## Comments on Volume 6 Environmental Statement 6.2.5 Air Quality submitted at Deadline 7.

AQ_ES_HumanReceptors_A01

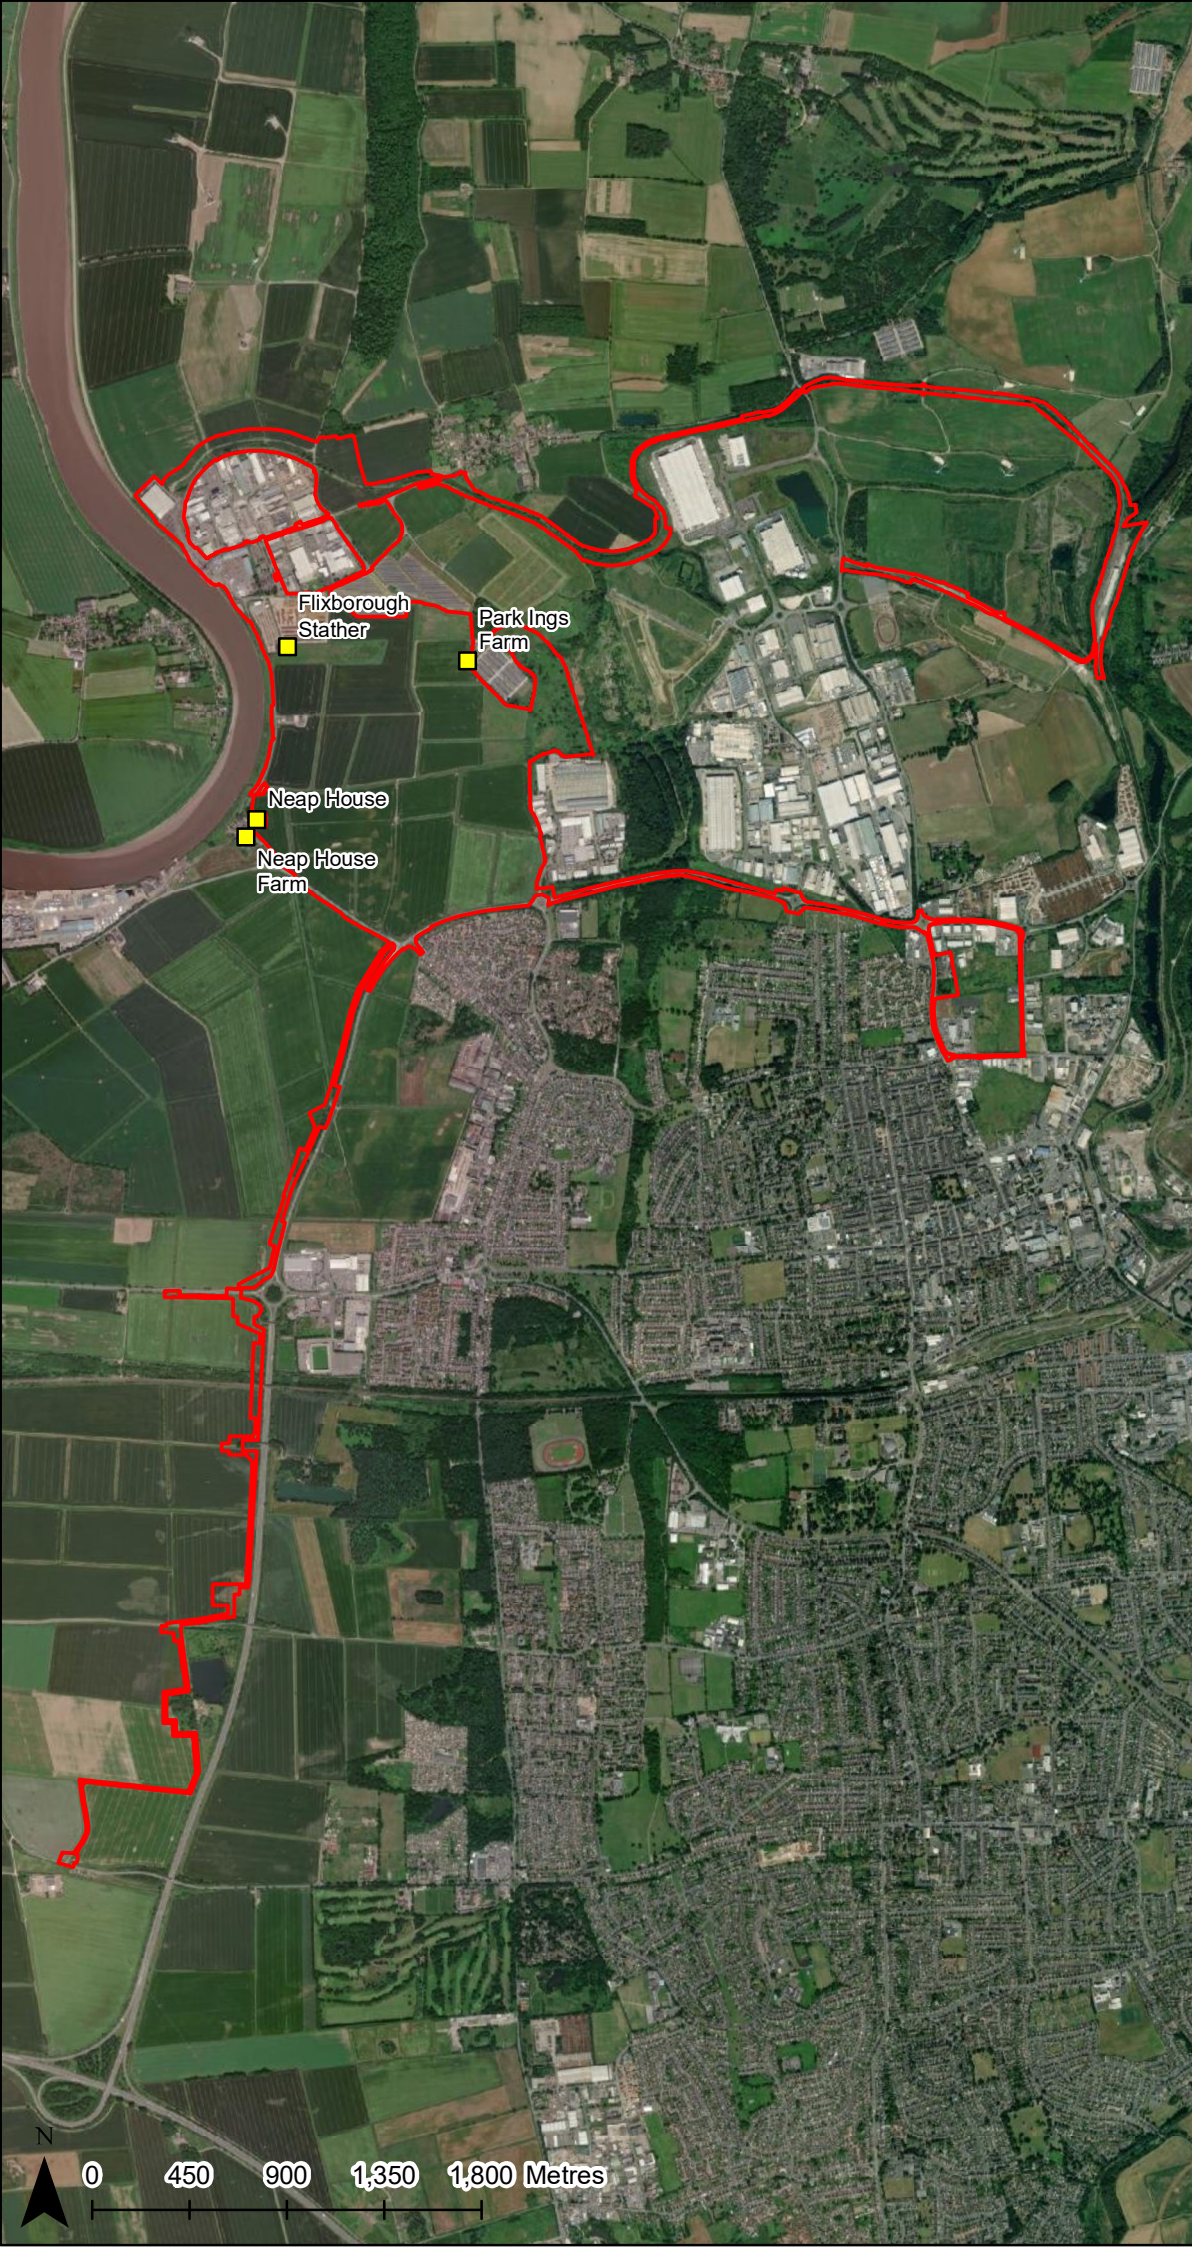
Why in Appendix A do Figures 1a,1b, 4,5,6,7 and 8 only identify 4 human receptors, none of which are the villages directly impacted by the project. Some human receptors identified are further away from the order limits than the villages of Amcotts and Flixborough.

AQ_ES_Contours_NO2_1_Hour_A01

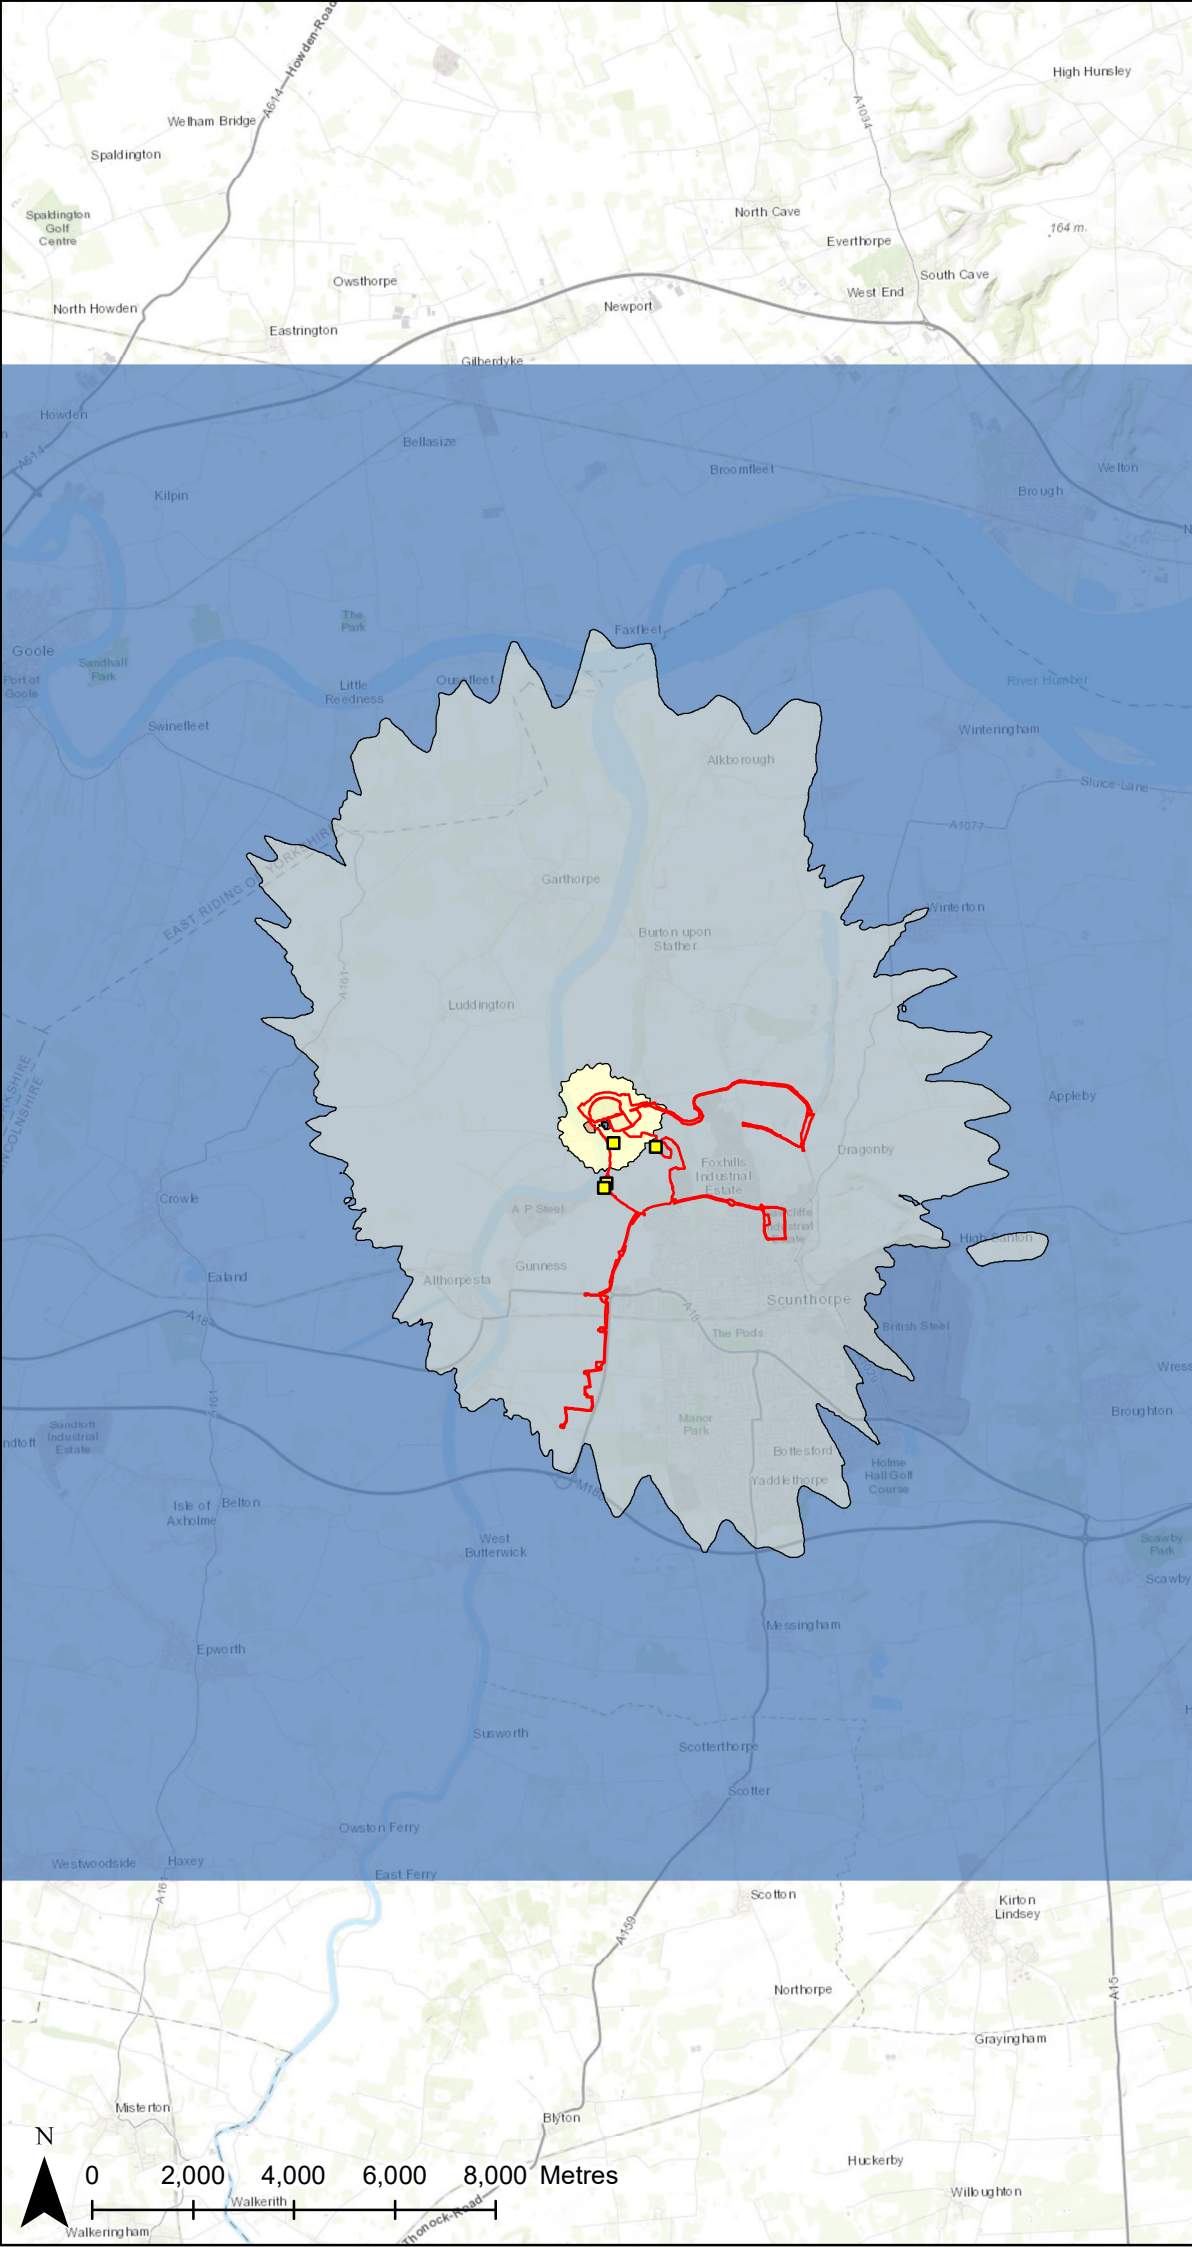
With reference to Appendix A, pages 97 to 107 of the report, particularly Figures 4 to 8 on pages 102 to 106. Can the applicant explain why both Amcotts and Flixborough villages' names have been omitted from the pollution map when these two receptors are going to be impacted by the N20, NOx and PM10 the most, apart from the order limits? Is the applicant trying to make the public believe there are no nearby villages that will be affected by the pollution that the proposed development will emit? I find it hard to understand why the villages that are going to be impacted less by the pollutants have been included and the ones which will feel the impact the most have been omitted.

The figure below is the applicants map from Appendix A figure 4. Why is this map so different to the National Grids even though it is from the British National Grids map?
